# Rezoning Transportation Analysis

Petition Number: 2022-210

Date	Description
05-24-2023	First Review (PDM)

RZ-03

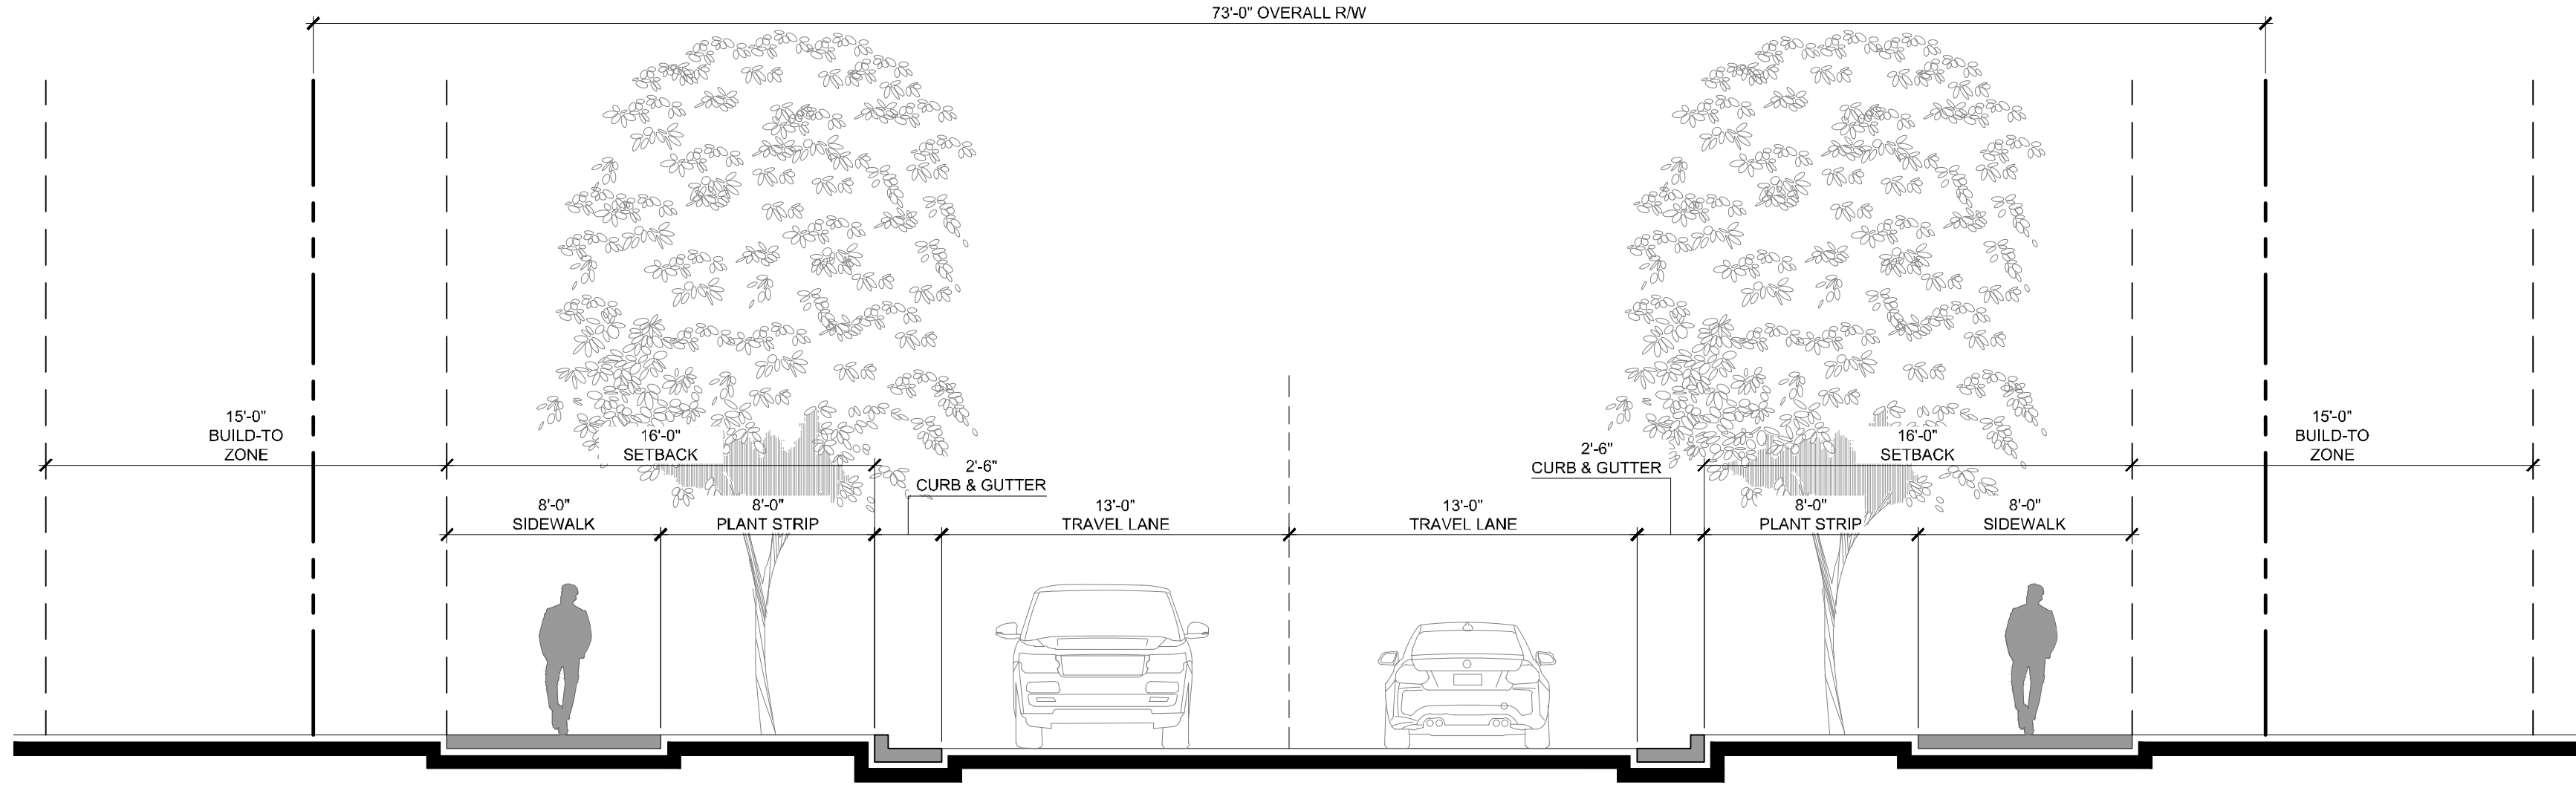
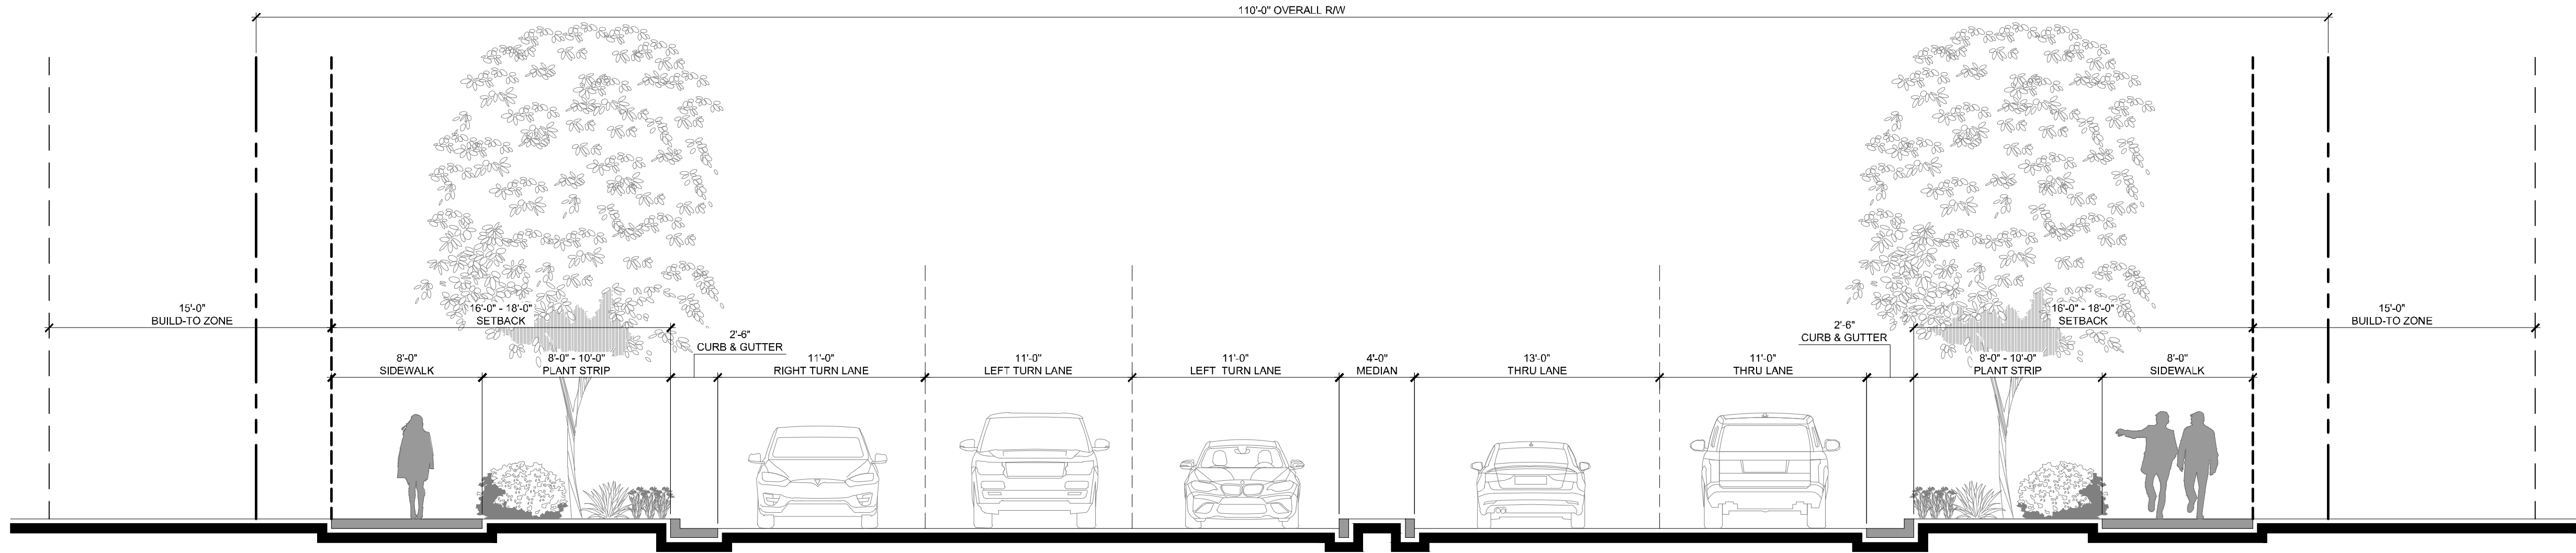
6. Revise internal street network to standard public street typical sections per the CLDSM or provide additional information on existing constraints for review and approval of nonstandard typical sections.

f. To allow modifications to the required public and network required street cross sections as generally depicted on Sheet RZ.01.

Provide additional info on why modifications are necessary
